**PLAN REVIEW SHEET**

Petition #: RZP 2022-069

Address: Inlivan/South Blvd.

Staff Contact: John Howard

TECHNICAL DATA SHEET

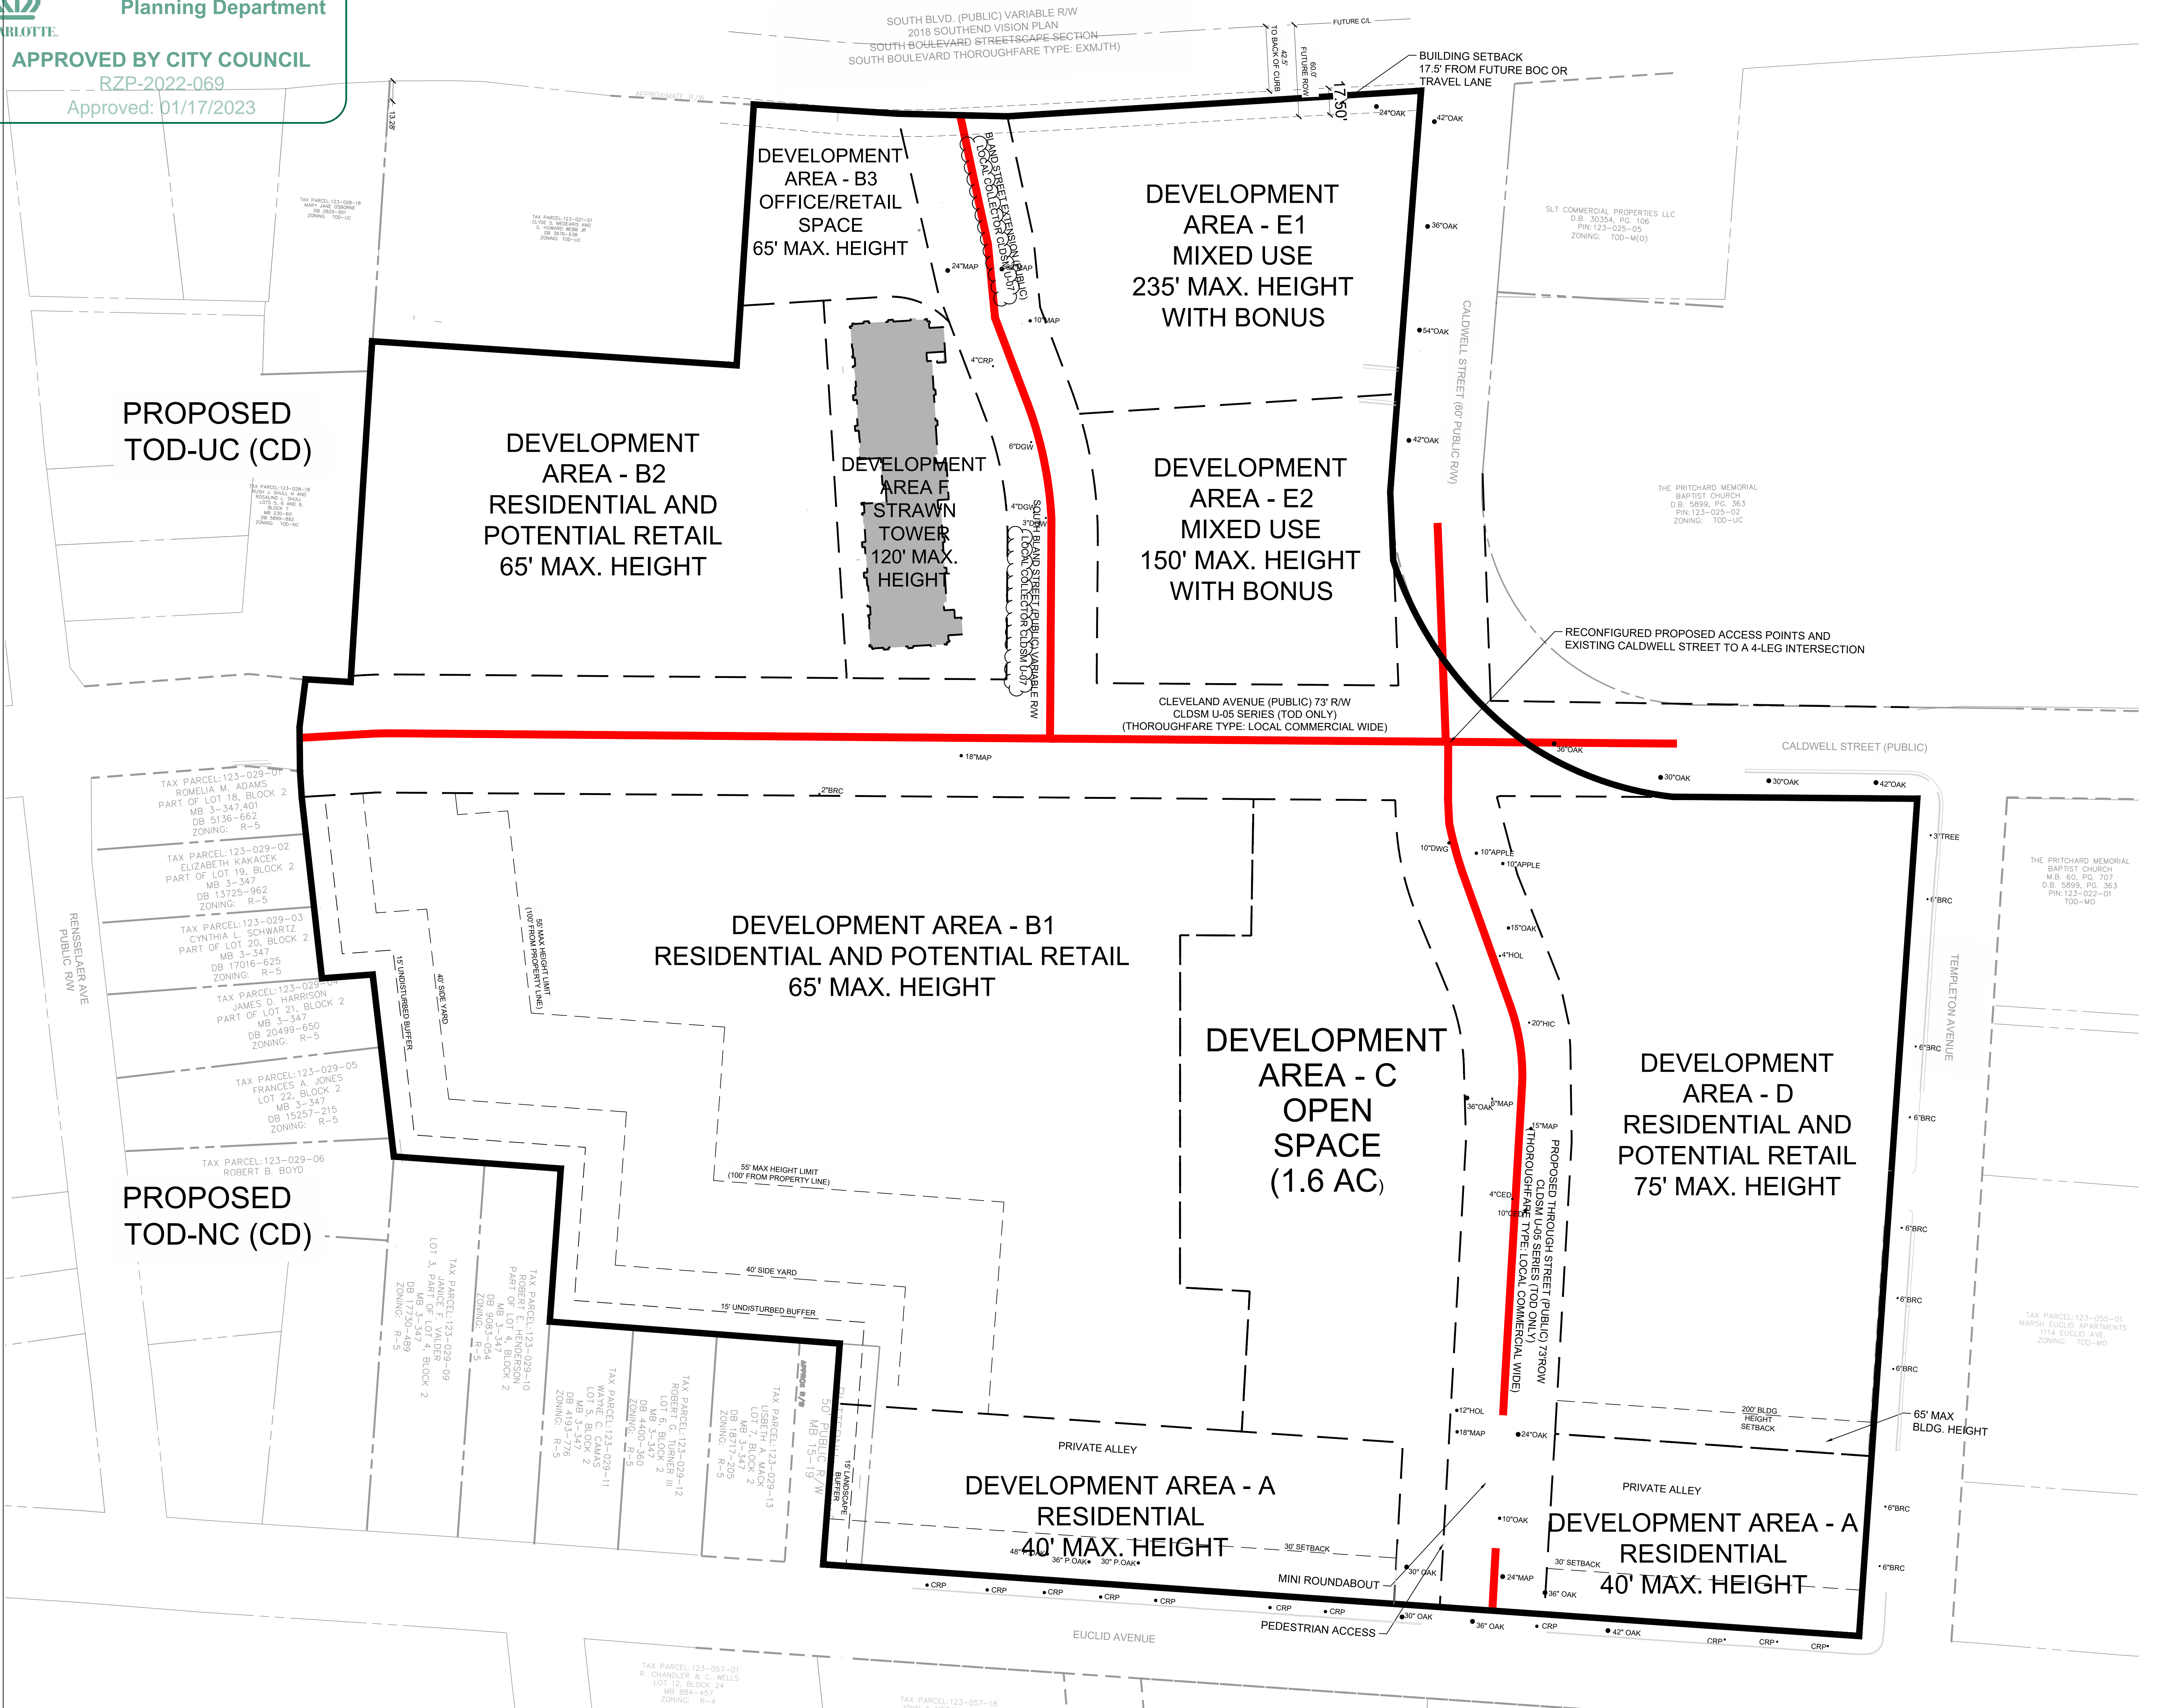
The site is located along CATS local bus routes #10 and #19 on South Boulevard. CATS has an existing shelter pad at this location. If any work done to the sidewalk, replace with detail 60.04A. Add bike parking and remove lamp post obstructing landing pad.
